FIVE ESTUARIES OFFSHORE WIND FARM

**Appendix E7 to Natural England's Deadline 7 Submission
Natural England's Benthic Ecology Advice on the Applicant's Deadline 5 Documents**

Planning Inspectorate Reference EN010115

03 March 2025

DRAWING TITLE: **Example of indicative cable protection length within the Margate and Long Sands SAC**

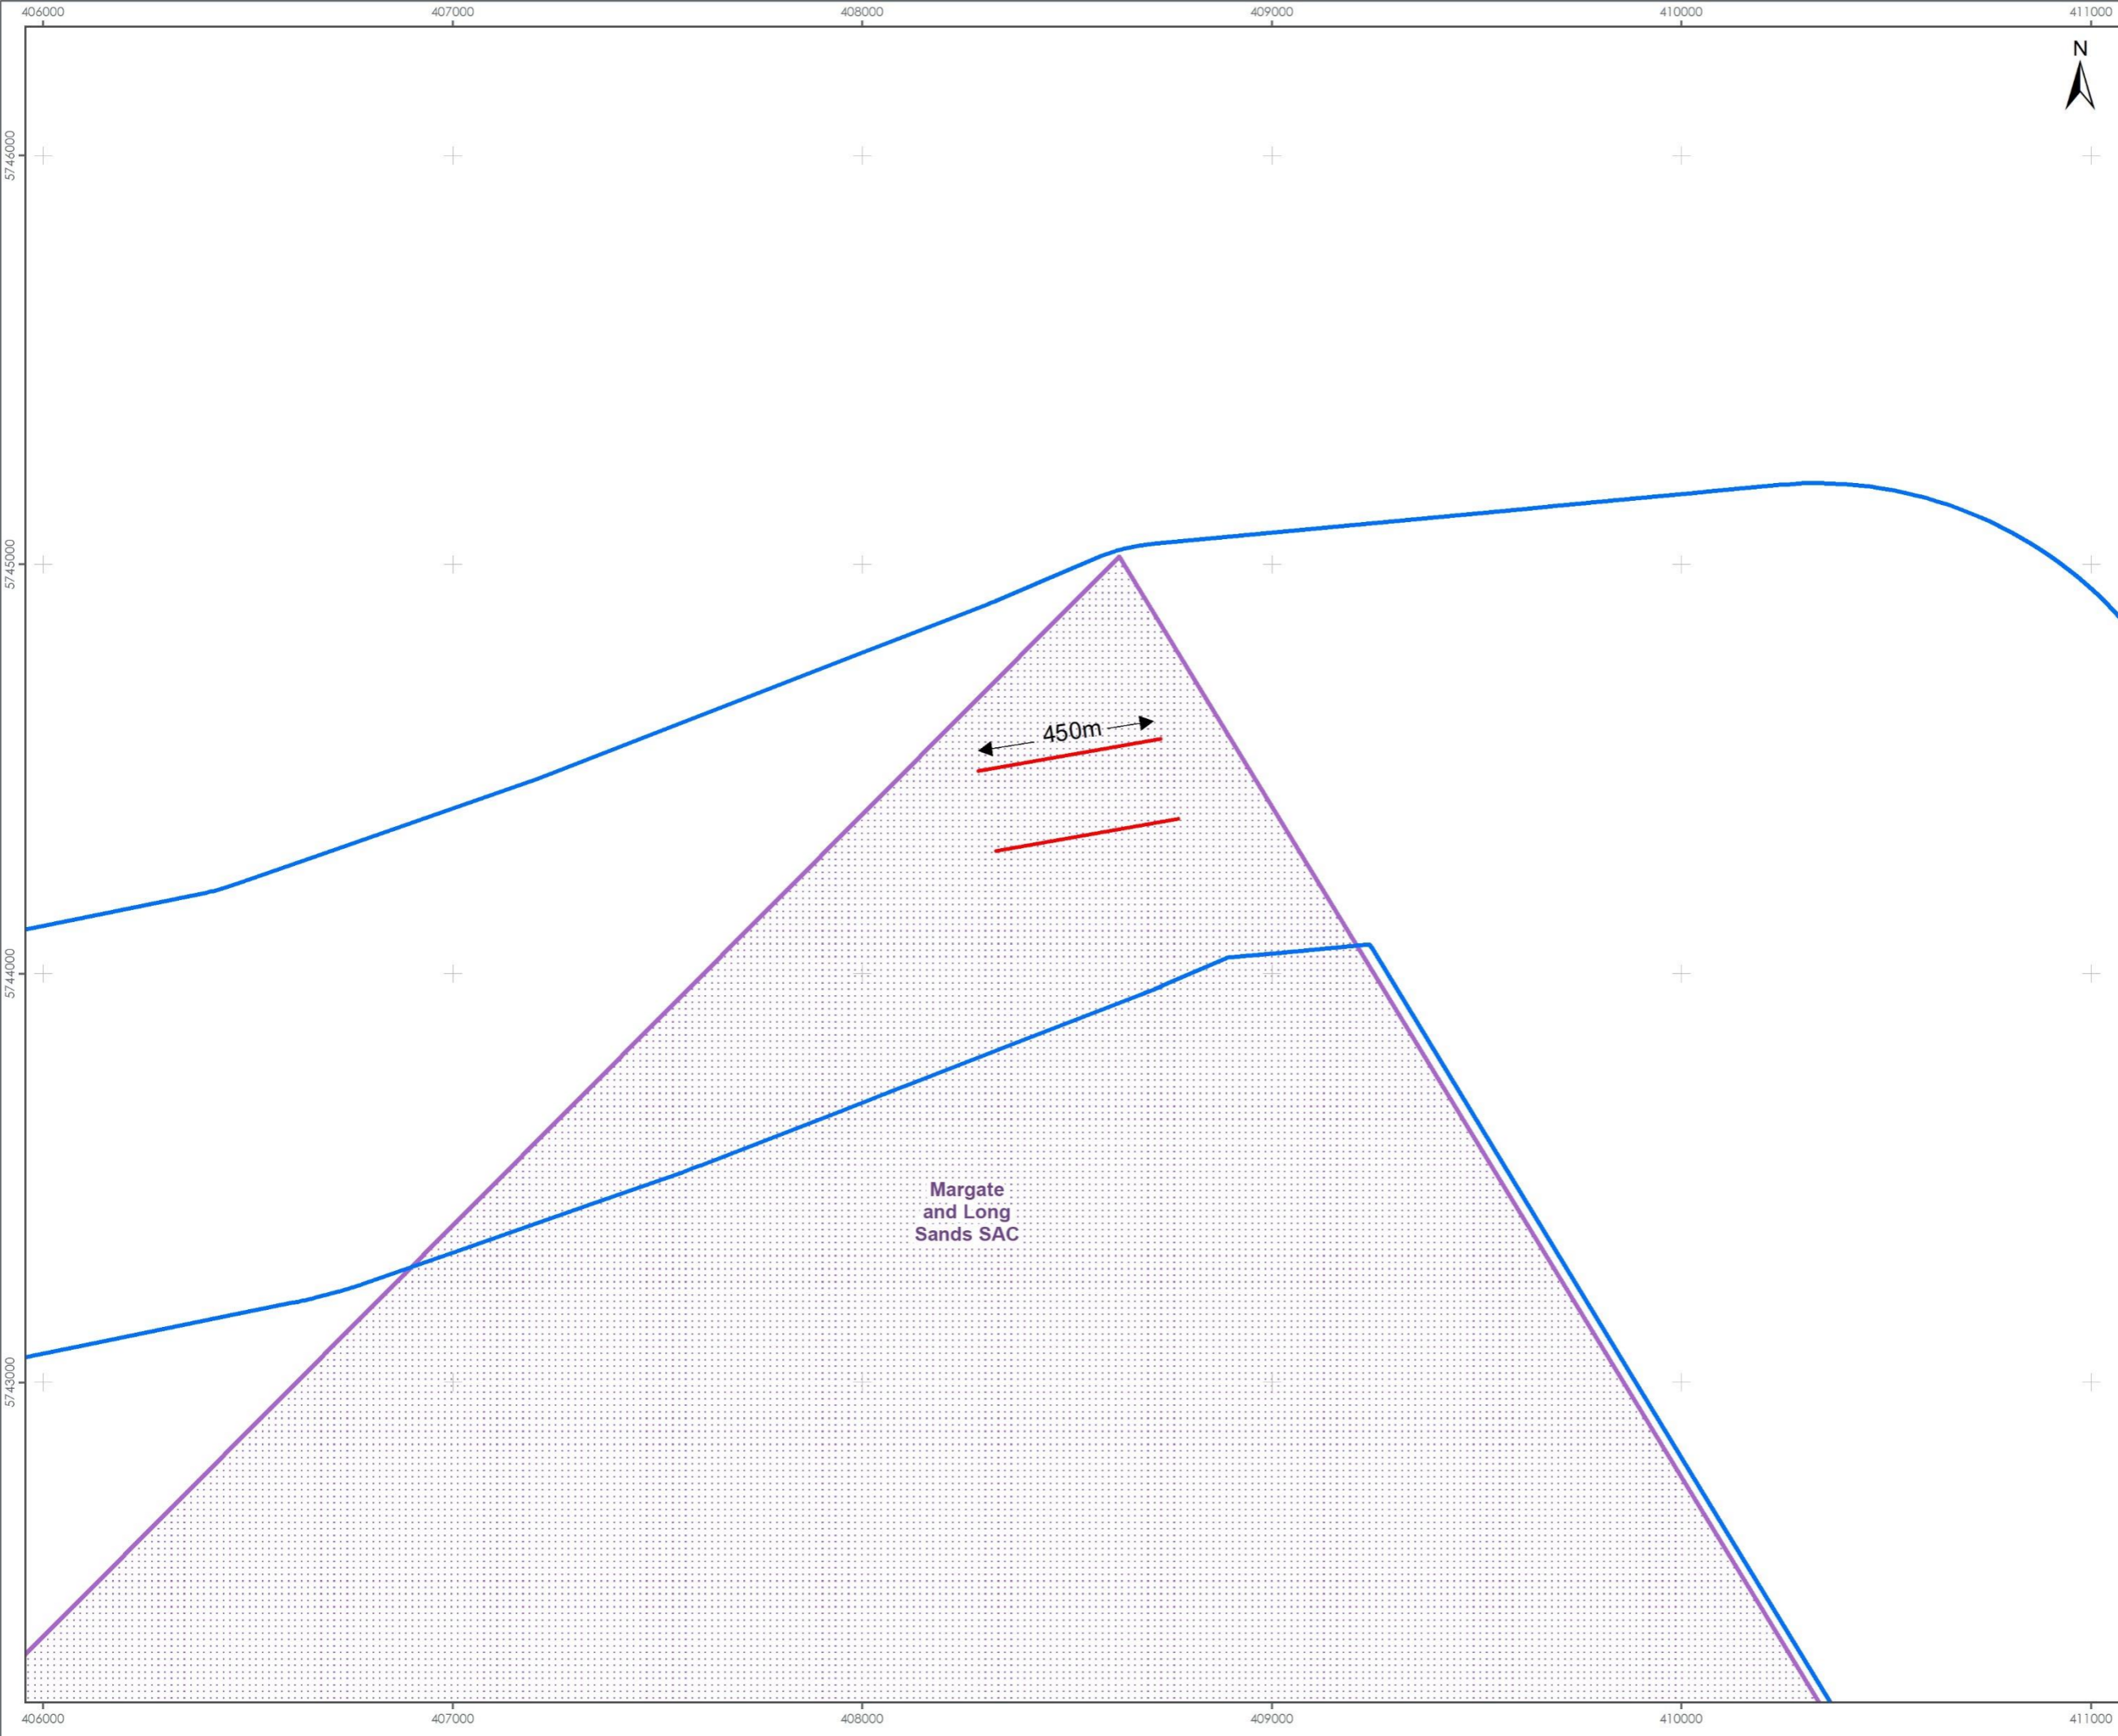
Document reviewed: [REP5-028] Five Estuaries 9.13 Margate and Long Sands Special Area of Conservation Benthic Mitigation Plan - Revision D (Tracked)			
NE Ref	Section	Key Concern and/or Update	Natural England’s Advice to Resolve Issue
1	Para 5.1.3	A weak commitment of “consideration will also be given to avoidance of other features (such as Priority Habitats under Section 41) and will consider any potential to subsequently reduce the recoverability time during final routing” has been added.	This commitment is not sufficient to address Natural England’s Concerns. Natural England advises that not only are impacts to NERC Habitats considered, but also avoided to provide the necessary mitigation measures
2	Para 7.1.1	Natural England welcomes the commitment to employ “readily removable” cable protection within M&LS SAC, together with a commitment to remove cable protection at the “end of life of the cables”. However, readily removable options should also take into account the environmental impacts from the removal operations.	<p>Natural England welcome these commitments but advise that they are not sufficient to address our concerns. We note that “end of life of cables” is ambiguous, it should be confirmed that end of cable life is the same as “end of project” (noting that cable lifespan can extend to 50 years or more).</p> <p>We continue to advise that unless it can be demonstrated otherwise, the scale of impacts is likely to hinder the ‘maintain’ habitat feature conservation objective of the site whilst cable protection is in situ, and potentially beyond, due to limitations in the ability to remove the infrastructure.</p> <p>Natural England advises that environmental impacts from the removal of cable protection should be considered at the consenting phase and only those external protection options that would minimise the environmental impacts included within the Rochdale envelope.</p>
